## A303 Amesbury to Berwick Down

TR010025

**8.39 - Comments on any further information requested by the ExA and received to Deadline 4 and 5 regarding the draft Development Consent Order**

<b>Version</b>	<b>Date</b>	<b>Status of Version</b>
Rev 0	26 July 2019	Deadline 6 Issue

PROPOSED BORED TUNNEL - (WORK No. 1F)

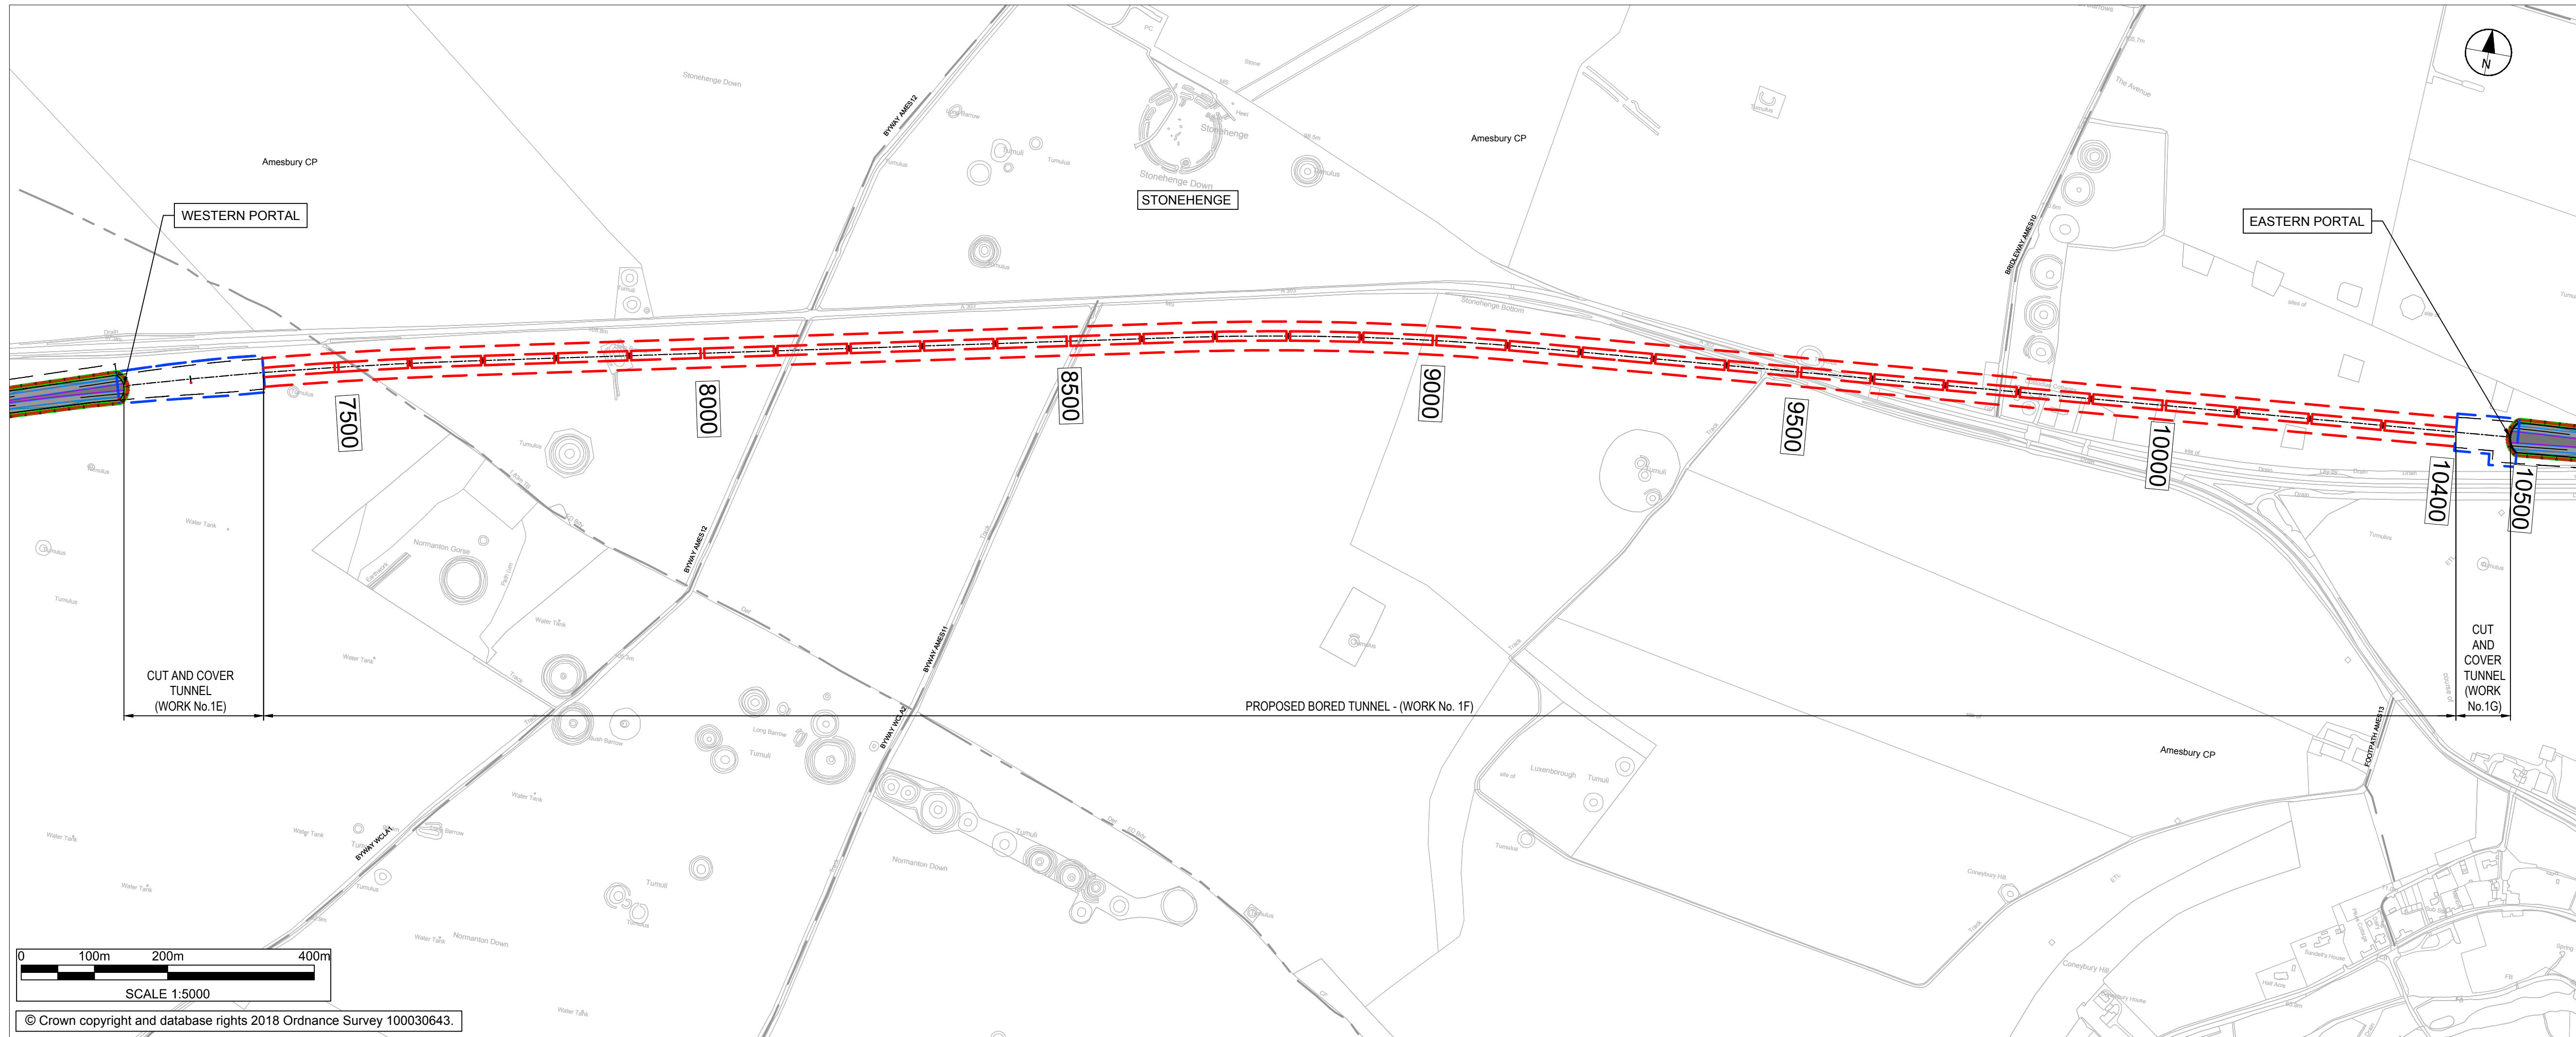
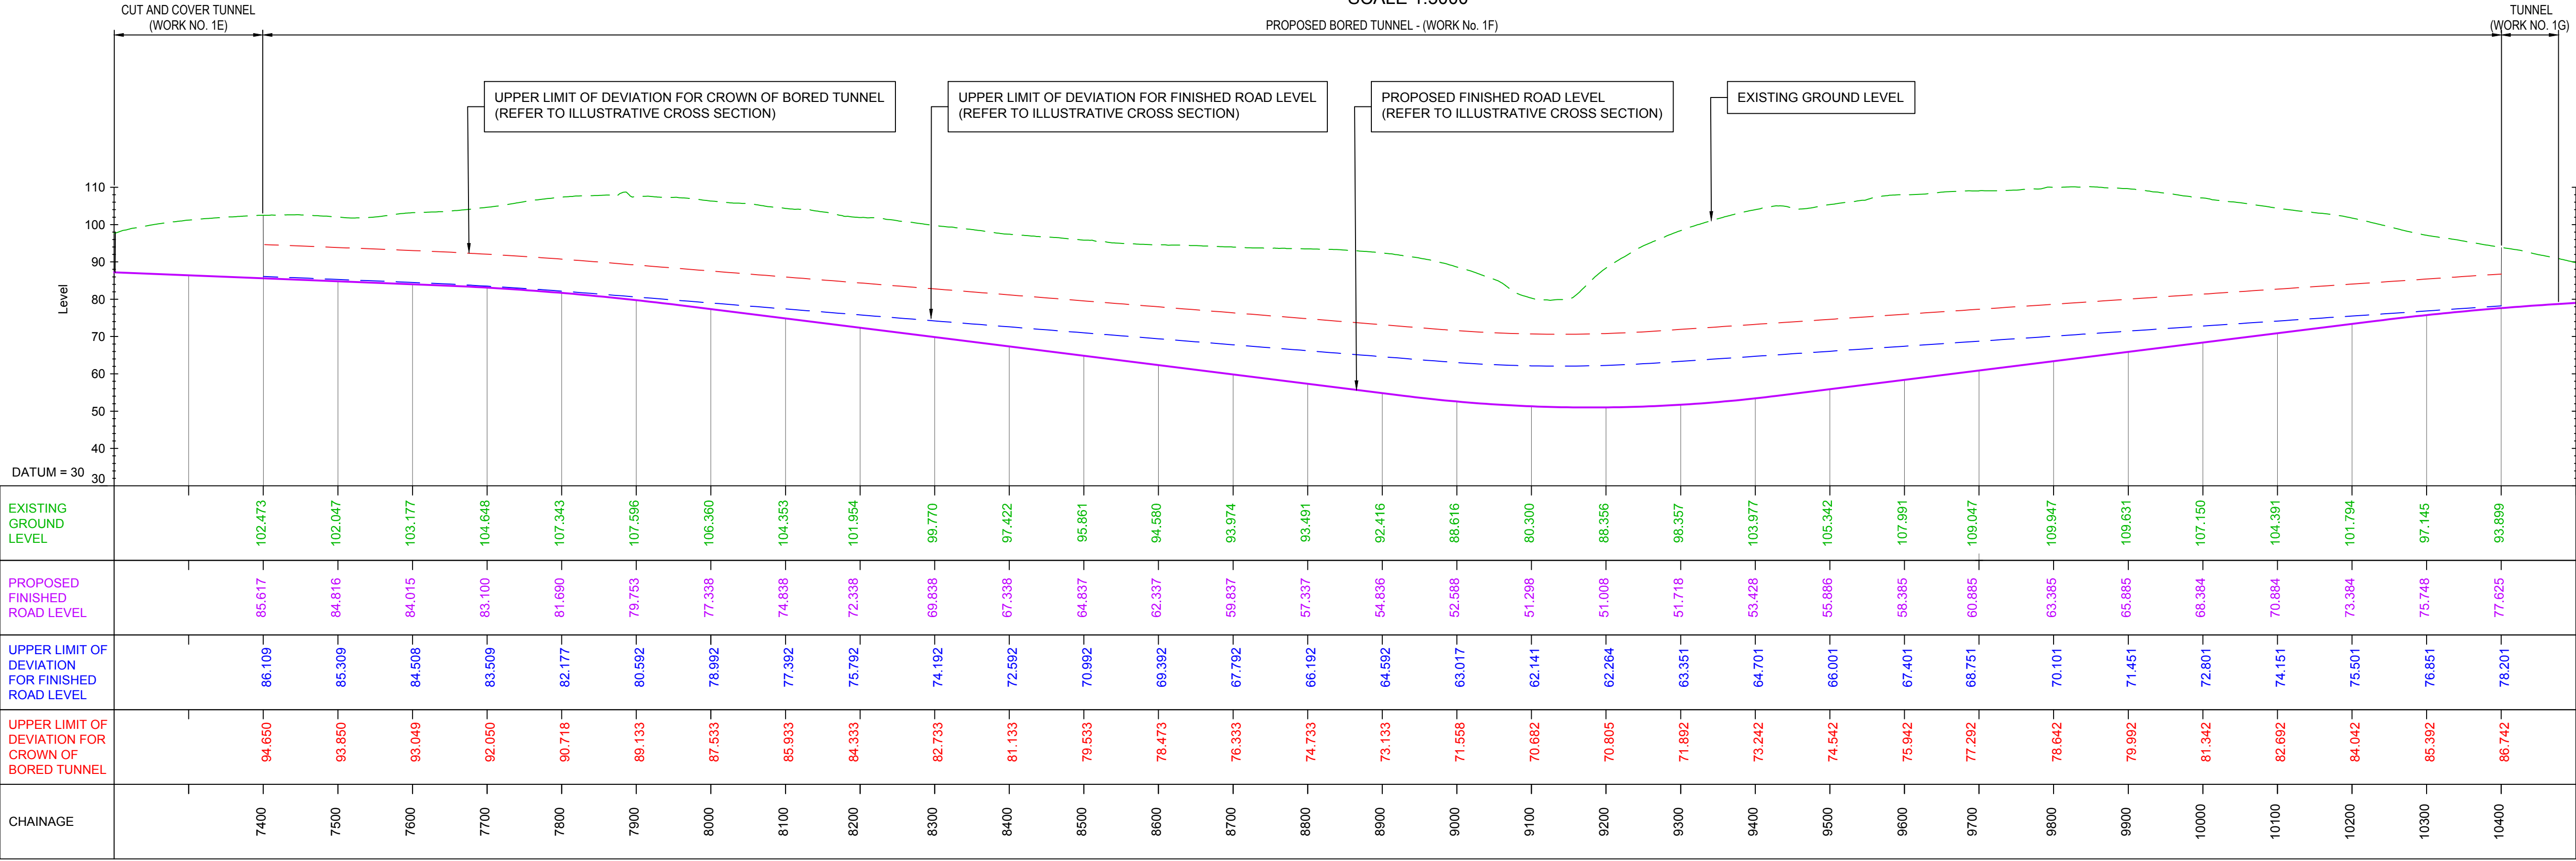
22	EA	<p><b>[REP4-049] section 1.2 in respect of Article 7 (Limits of deviation)</b></p> <p>It is noted that Limits of Deviation to the vertical and lateral alignment of the tunnel are to be set by the DCO to allow for changes in the currently proposed design during detailed design by the contractor.</p> <p>The Bored Tunnel Limits of Deviation Plan (TR010025-2.16 Rev P02) submitted with the DCO application indicates an upper limit for the crown of the tunnel at 70 mAOD at the lowest point of the tunnel - beneath Stonehenge Bottom - and no lower limit to its vertical alignment.</p> <p>The groundwater risk assessment to date (most recently updated in Implications of 2018 Ground Investigations to the Groundwater Risk Assessment, P04. AECOM, Mace, WSP, April 2019) has assessed the impacts of an alignment where the crown, at its lowest point – beneath Stonehenge Bottom – is 55 mAOD. This assessment places the tunnel beneath the expected elevation of the Whitway Rock which is thought to act as a preferential flow horizon (although the presence of these and exact location has not been confirmed to date). Due to the risk of the tunnel impeding flow along this horizon should its alignment, design or construction methodology change, it is essential that any changes to the detailed design are adequately risk assessed. The EA should be consulted on any updated design and risk assessment and agreement reached with the</p>	<p>The Applicant has responded to this point in a post hearing note included in its summary of oral submissions at the DCO ISH [REP4-029] under agenda item 3.5, reproduced below for ease of reference:</p> <p><i>"Post Hearing Note: in response to concerns raised by the Environment Agency in relation to the interaction between the vertical limits of deviation of the proposed tunnel and groundwater flows, it should be noted that the Applicant responded to this point in part at Deadline 3, as part of its comments on written representations [REP3-013].</i></p> <p><i>The Environmental Statement has assessed the impacts on groundwater flows as a result of the Scheme, including the tunnel. A precautionary approach was taken in respect of the tunnel alignment and depth. The Outline Environmental Management Plan includes controls in respect of groundwater impacts, particularly by reference to the obligation in item MW-WAT10 to produce a Groundwater Management Plan in consultation with the Environment Agency. This would include a risk assessment in relation to the final design, as well as a monitoring regime with trigger levels and actions. There are therefore sufficient controls in place to ensure any impacts on groundwater flows would be mitigated adequately. It should also be added that the Environment Agency has further controls by virtue of the protective provisions for its benefit contained in Part 5 of Schedule 11 to the draft Development Consent Order."</i></p> <p>The Applicant further notes that the limits of deviation in article 7 establish the parameters for the authorised development for which the Applicant seeks development consent and it would be unnecessary to require consultation on their exercise for the reasons that the limits of deviation have been thoroughly assessed in the Environmental Assessment (see Chapter 2, [APP-040]) and that further detailed consultation continues to take place throughout this Examination. This position is consistent with that set out at Issue Specific Hearing 1 on the Development Consent Order, held on 4 June 2019 and contained within the Written</p>

24	Historic England	<p><b>[REP4-084] paragraphs 111 to 115 in respect of Article 7(6) (limits of deviation)</b></p> <p>Suggestion that the exceedances of vertical limits of deviation that could be certified by the Secretary of State under this provision could restrict future archaeological research and that the exercise of the provision ought to require consultation with Historic England.</p>	<p>The Applicant does not accept the suggestion that the project assessed in the Environmental Statement differs from the project for which the Applicant seeks development consent. Despite the suggestion in paragraph 112, the draft DCO clearly includes requirements, in Schedule 2, design principles in the OEMP [REP4-021] (which are being developed with Historic England and other heritage stakeholders) and protective provisions, in Schedule 11.</p> <p>With respect to the suggestion that this provision could restrict future archaeological research, it is not clear to the Applicant how this could be the case. The tunnel restrictions imposed under article 27 are to protect the integrity of the tunnel, would apply from the tunnel bore to the surface. The precise level below ground of the bored tunnel would not affect the extent of land that would be subject to the tunnel restrictions.</p>

26	Historic England	<p><b>[REP4-084] paragraphs 121 to 125 in respect of Article 7(7)(b) (limits of deviation)</b></p> <p>Expresses concerns that article 7(7)(b) authorises departures from the design of any tunnel or tunnel structure and vary the number of tunnel cross passages shown on the engineering section drawings (plan and profiles and the engineering section drawings (cross sections)</p>	<p>Article 7(7)(b) serves two purposes. Firstly, it enables the detailed design of the bored and cut and cover tunnels to be developed, within the limits of deviation, without being constrained to the reference design shown illustratively on the Engineering Section Drawings (Cross Sections) and (Plans and Profiles). It must be noted that this applies only to the <i>design</i>, the levels from which the vertical limits of deviation are drawn, remain fixed. Secondly, it enables the detailed design to vary the number of cross passages between the tunnel bores. In either case, the degree of flexibility afforded is constrained by the requirement for the variation to not give rise to any materially new or materially worse adverse environmental effects in comparison with those reported in the environmental statement.</p> <p>The provision is necessary as at this stage the detailed design and engineering detail of the cut and cover and bored tunnel has yet to be determined. Similarly, the precise location and number of cross passages between the bored tunnels has yet to be finally determined. The provision is proportionate as it is constrained to not giving rise to any materially new or materially worse adverse environmental effects. In addition this provision remains subject to the requirements, in particular the design commitments, design principles and process of stakeholder consultation on aspects of the detailed design specified in the OEMP, compliance with which is secured by requirement 4.</p>

<p>EA regarding conclusions and any mitigation measures proposed.</p> <p>We would welcome consultation with us before the proposed Limits of Deviation for the tunnel could be invoked.</p>	<p>Summary of Oral Submissions of that Issue Specific Hearing [REP4-029]. The Applicant considers that the measures in the OEMP referred to above would appropriately address the Environment Agency's concerns in a focussed manner, without imposing the unnecessary and duplicative requirement to consult.</p>
23	Historic England	<p><b>[REP4-084] paragraphs 105 to 110 in respect of Article 7(2) (limits of deviation)</b></p> <p>Concerns raised with where the term of "limits of deviation", defined in article 2(1), elsewhere in the Order other than in article 7.</p> <p>Concerns raised that the limits of deviation may be exercised where "necessary or convenient", suggestion this should be amended to read only where "necessary".</p>	<p>The Applicant confirms that the phrase "limits of deviation" is used only in articles 2 and 7 in the operative provisions of the draft DCO. The phrase is also used in Parts 3 and 5 of Schedule 11, the protective provisions for the drainage authorities and the Environment Agency respectively, in respect of the Applicant's duty to maintain drainage works.</p> <p>The use of the phrase "necessary or convenient" in the drafting of limits of deviation provisions is considered in detail in the Applicant's response to question DCO.2.11.</p>

<p>It should further be noted that the vertical limits of deviation for surface infrastructure within the World Heritage Site have deliberately been drawn very narrowly. For example Work Nos. 1D(i) (Green Bridge Four), 1E(i) (the western cut and cover tunnel) and 1G(i) and (ii) (the eastern cut and cover tunnel and tunnel service building) are only permitted to deviate by 0.25m from existing ground levels. Regarding consultation arising from any application for a certificate under article 7(6), please see the Applicant's response to the Examining Authority's question DCO.2.12.</p>
25	Historic England	<p><b>[REP4-084] paragraphs 116 to 120 in respect of Article 7(7)(a) (limits of deviation)</b></p> <p>Raises concerns with the perceived degree of flexibility in the limits of deviation as they relate to the Green Bridge 4.</p> <p>Advises that the width of Green Bridge Four should be no less than 150m, and this must be secured in the DCO.</p>	<p>As confirmed at the DCO ISH (see REP4-029 under agenda item 3.5), the location of Green Bridge Number 4 would not be affected if the 200m westward limit of deviation for the commencement/termination of points Work Nos. 1E, 1D and 1F is utilised. Please also see the Applicant's response to DCO.2.13 which confirms the location, by reference to its chainage, of where Green Bridge Four would cross the new A303.</p> <p>In determining the width and location of Green Bridge No. 4, Highways England has carefully assessed the benefits of reconnecting heritage assets against the disbenefits of doing so, including the fact that a bridge of more than 150m would be classified as a tunnel under Highways England's Design Manual for Roads and Bridges (DMRB), Volume 2, Section 2, Part 9 (Design of Road Tunnels – BD78/99), resulting in significant and disproportionate implications for the scheme in terms of design standards and costs. Highways England believes the proposed solution achieves the appropriate balance of these matters.</p> <p>Reference D-CH4 of the OEMP [REP4-021] secured the width of Green Bridge Four at "approximately 150m". To address Historic England's concerns regarding the term "approximately" this measure has been updated in the OEMP submitted for deadline 6 to give a range for the width of Green Bridge Four.</p>
